Further to your request for further flood assessment of the Newcastle Grammar School – Park Campus (SSD-13895306) proposal. Water Floodplain and Coast officers have reviewed the response to submissions and provide the following information *without prejudice* for your consideration. (Please note that detailed comments are provided at Attachment A

### Newcastle Grammar School – Park Campus Stage 1

#### Detailed comments - Response to Submissions for City of Newcastle

#### Flooding and flood risk comments

**Block B Ground Floor Plan**

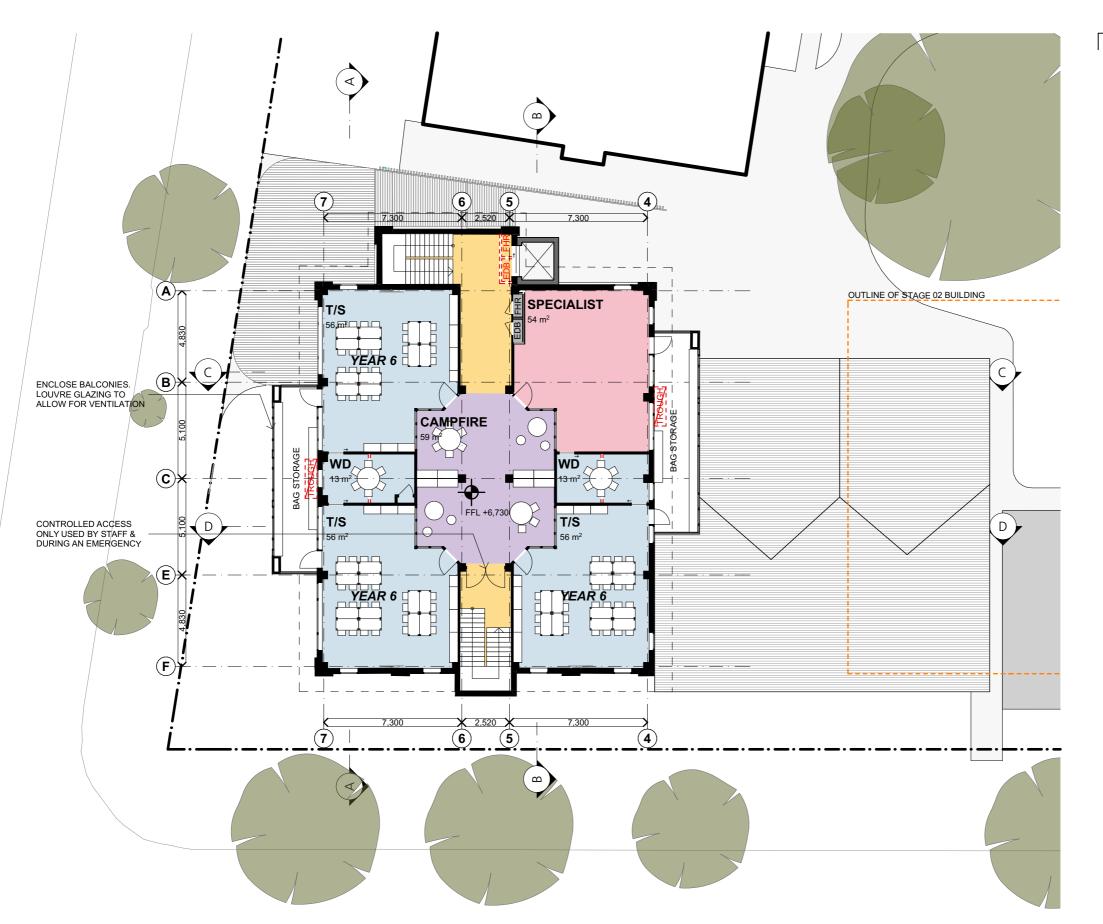
- The architectural plans show that the admin staff will not have a direct view of the hockey fields or the on-site flood marker as they will be located on the ground floor of Building B.
- The current flood marker is located outside the current library / admin building, which will be demolished as part of the stage 1 works.
